from
**Southern
Water**

Your ref
M/32/19/PL

Proposal: New dwelling & separate garage replacing the proposed new house in the previous planning permission ref: M/7/16/PL - Amendment to M/153/18/PL.

Site: M/32/19/PL: - 46 Sea Lane, Middleton-On-Sea, PO22 7RX.

Drainage diversions 1:250 @a3 (Indicative)

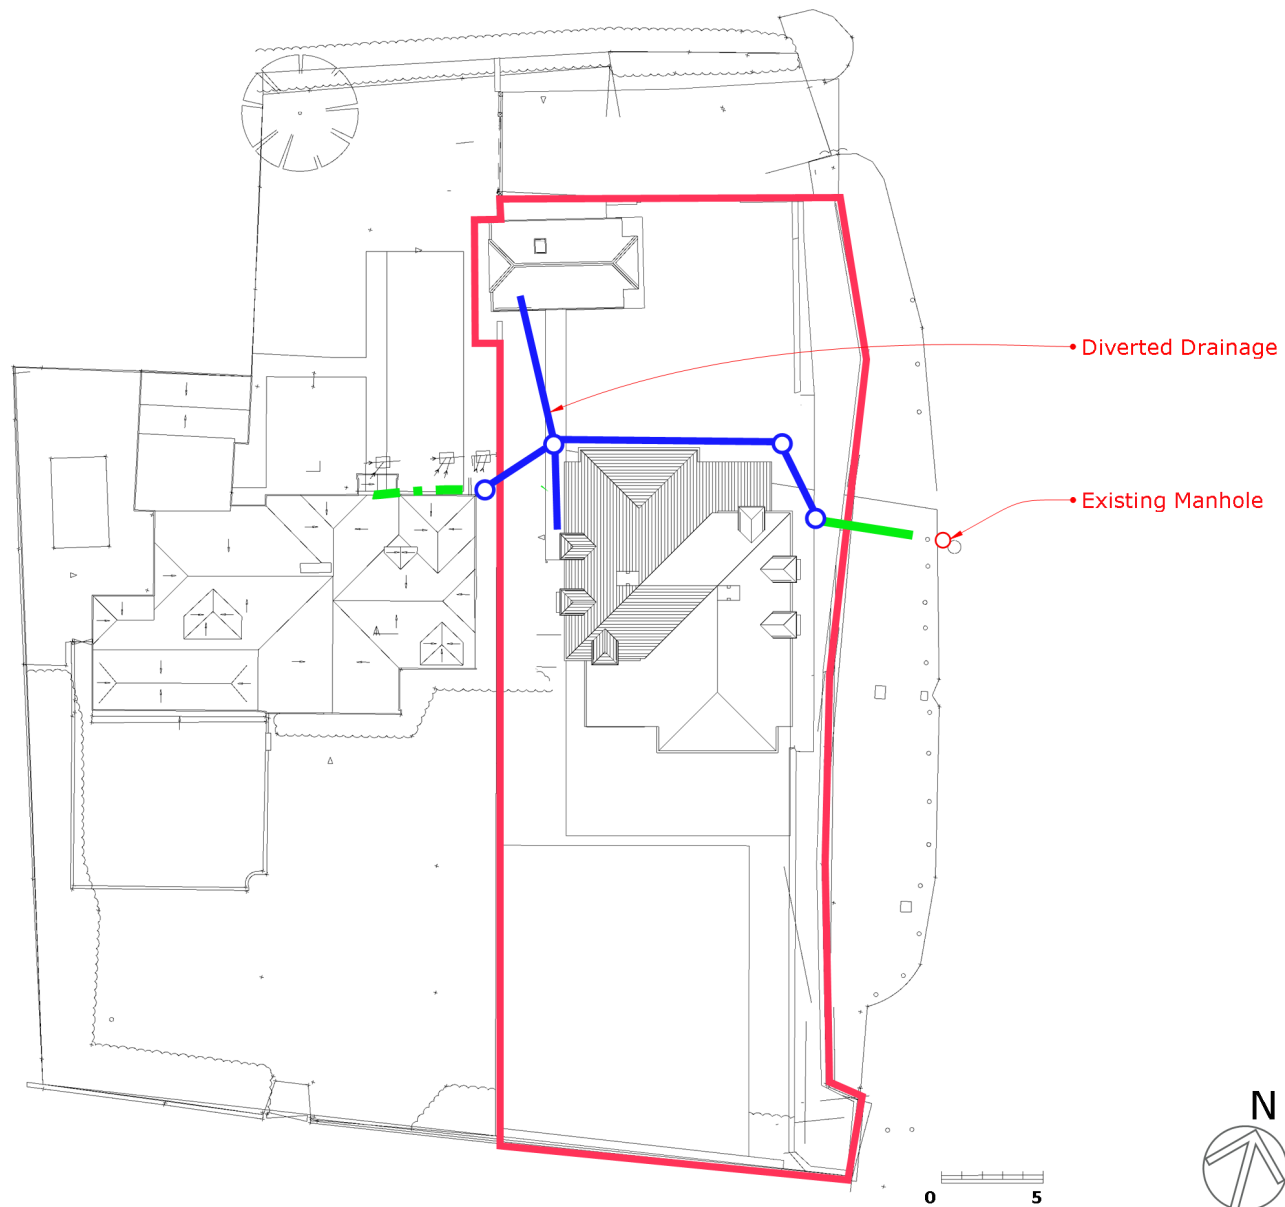
It appears that applicant is proposing to divert sewer serving neighbouring property and crossing the proposed site (not shown on our records). Southern Water requests a formal application for sewer diversion under S185 of Water Industry Act 1991 in order to divert any public sewer.
